From: Tom Errico <thomas.errico@tylin.com>
To: Jean Fraser <JF@portlandmaine.gov>
CC: David Margolis-Pineo <DMP@portlandmaine.gov>, Katherine Earley <KAS@port...>
Date: 3/12/2014 6:46 PM
Subject: 421 Warren Avenue

Jean - I have reviewed the application materials and conducted a field review of the site and offer the following preliminary comments.

PROJECT PH WARREN AVENUE, LLC
SHEET TITLE SITE LAYOUT AND UTILITY PLAN

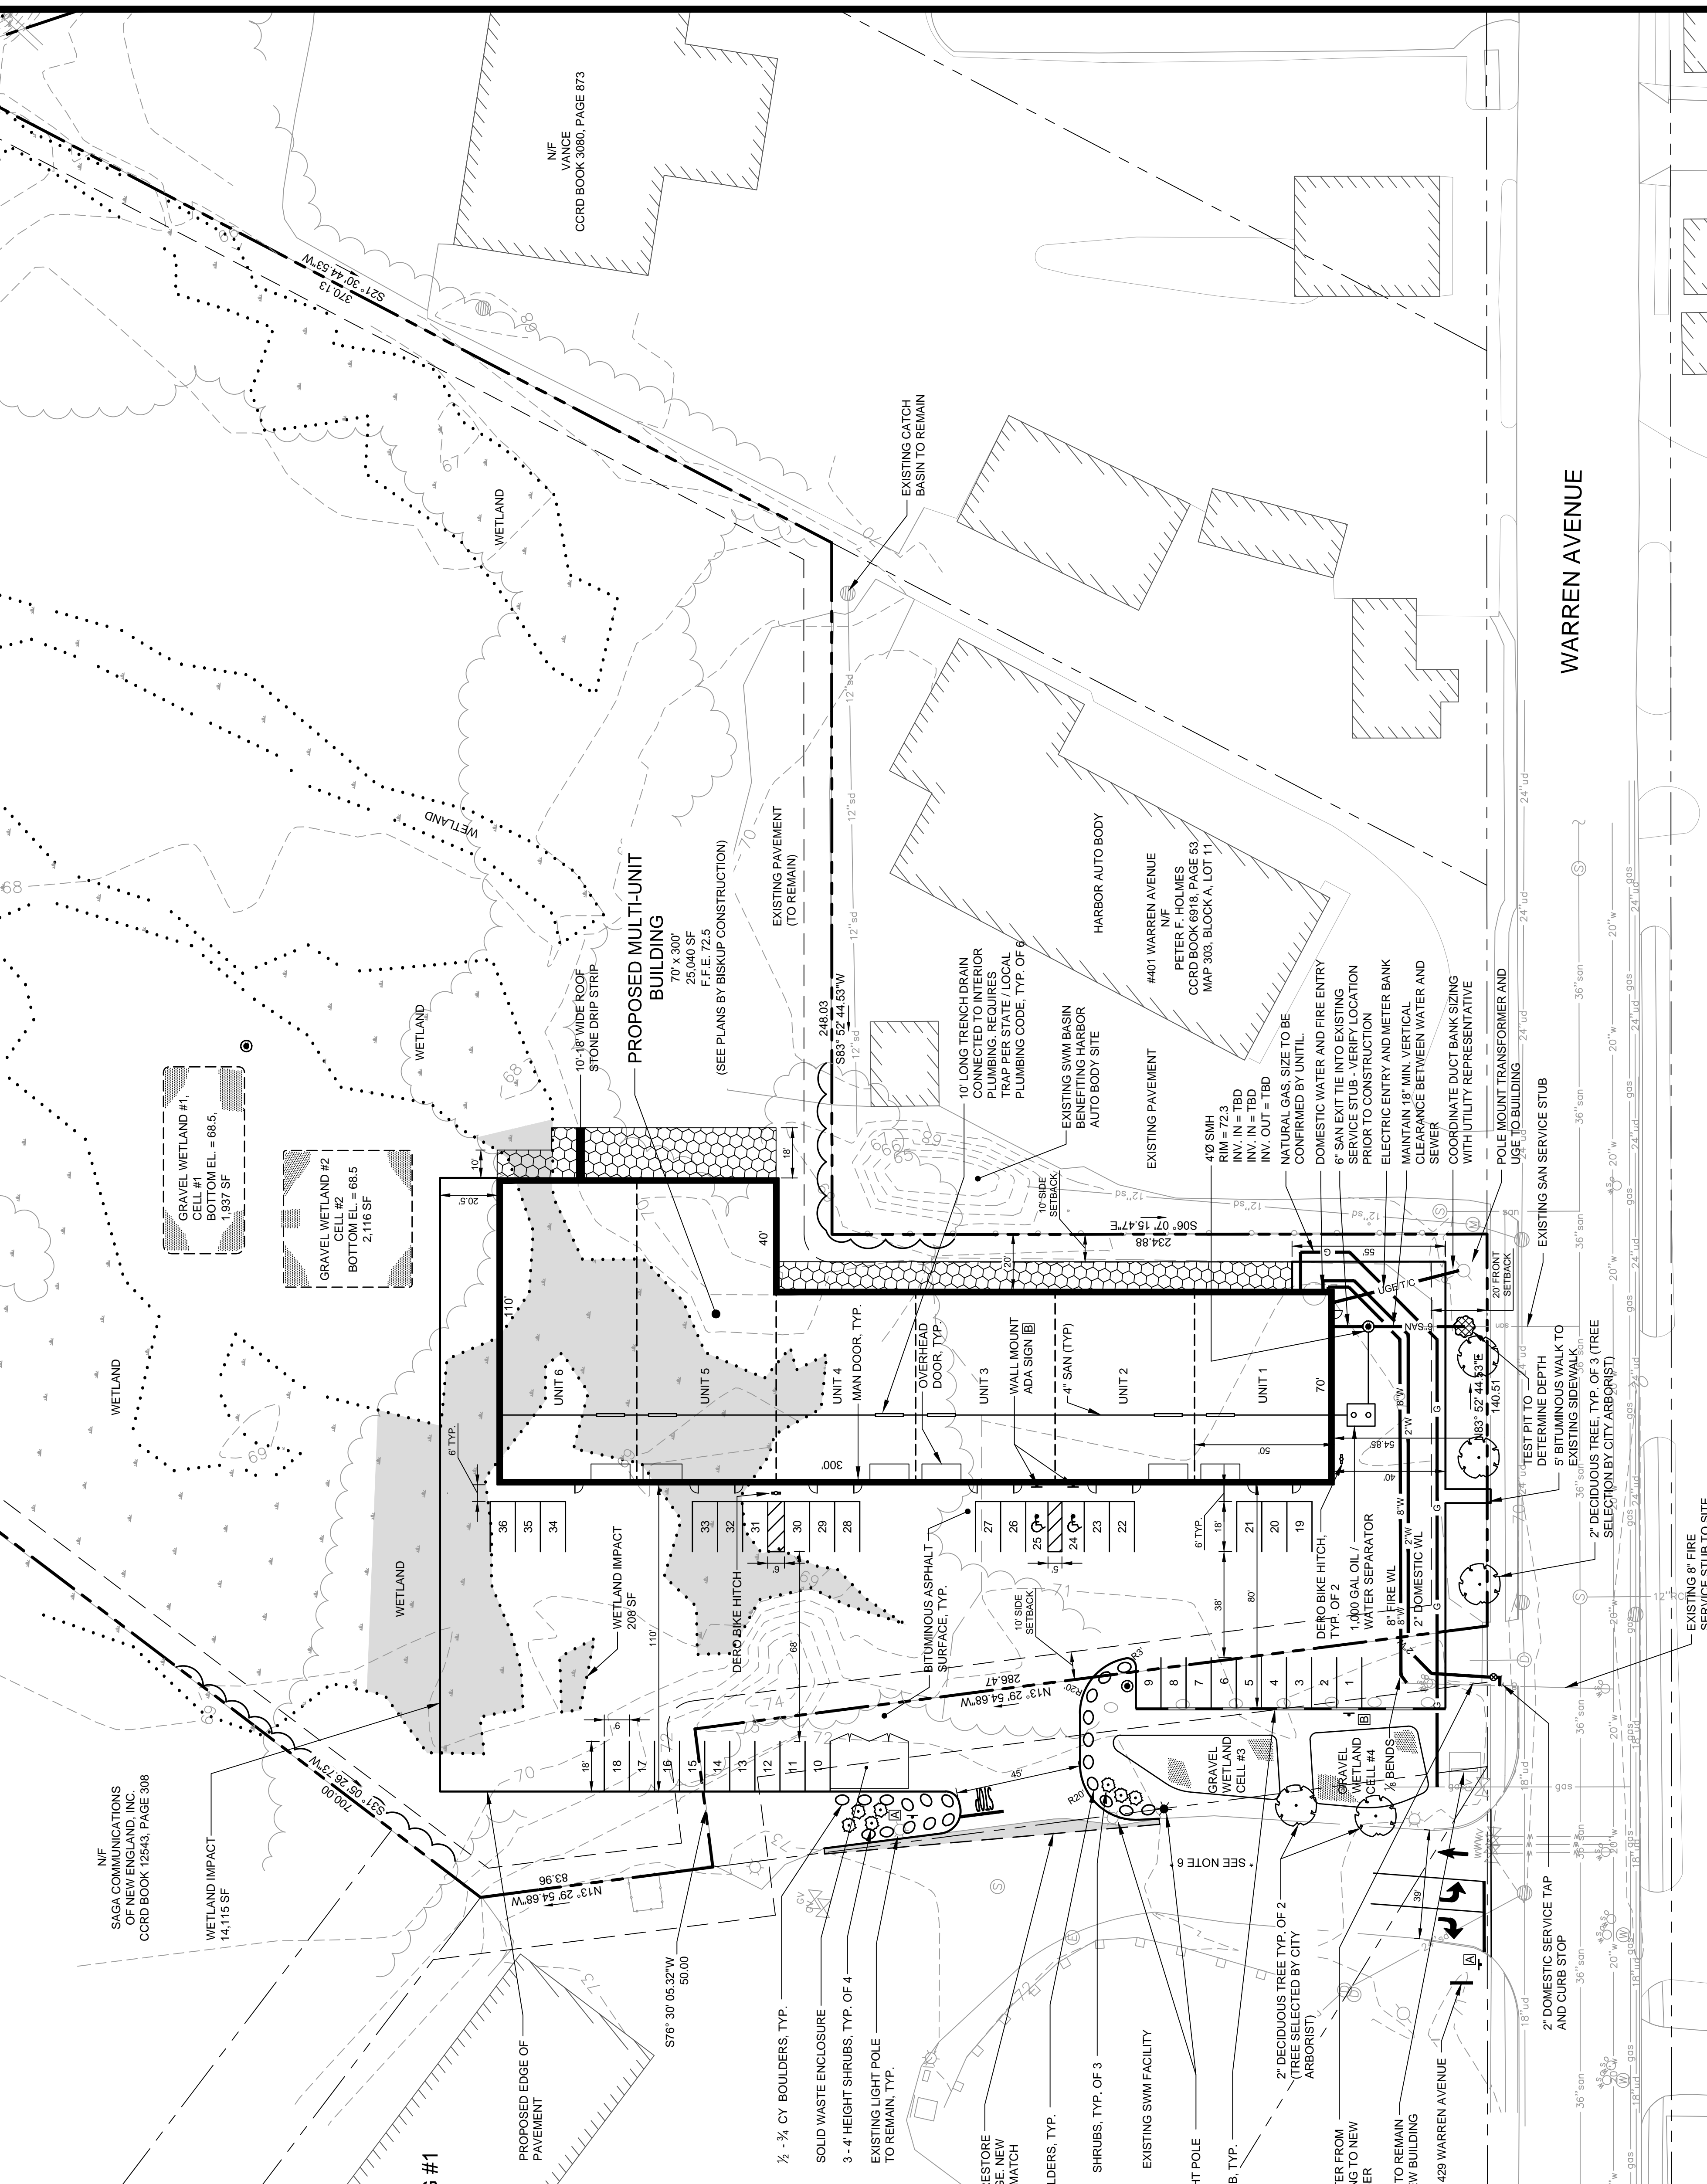
- * The proposed driveway entrance exceeds City standards and a waiver will be required. The applicant shall provide an Auto-Turn analysis documenting the need for the wide driveway.

- * The aisle widths in the internal parking/circulation area do not meet City standards and a waiver will be required. The applicant shall provide an Auto-Turn analysis documenting the need for the expanded pavement areas.

- * A sidewalk connection from the proposed building to Warren Avenue shall be provided.
- * An area along the building frontage on the parking area shall be marked such that pedestrians have a direct routing to Warren Avenue.
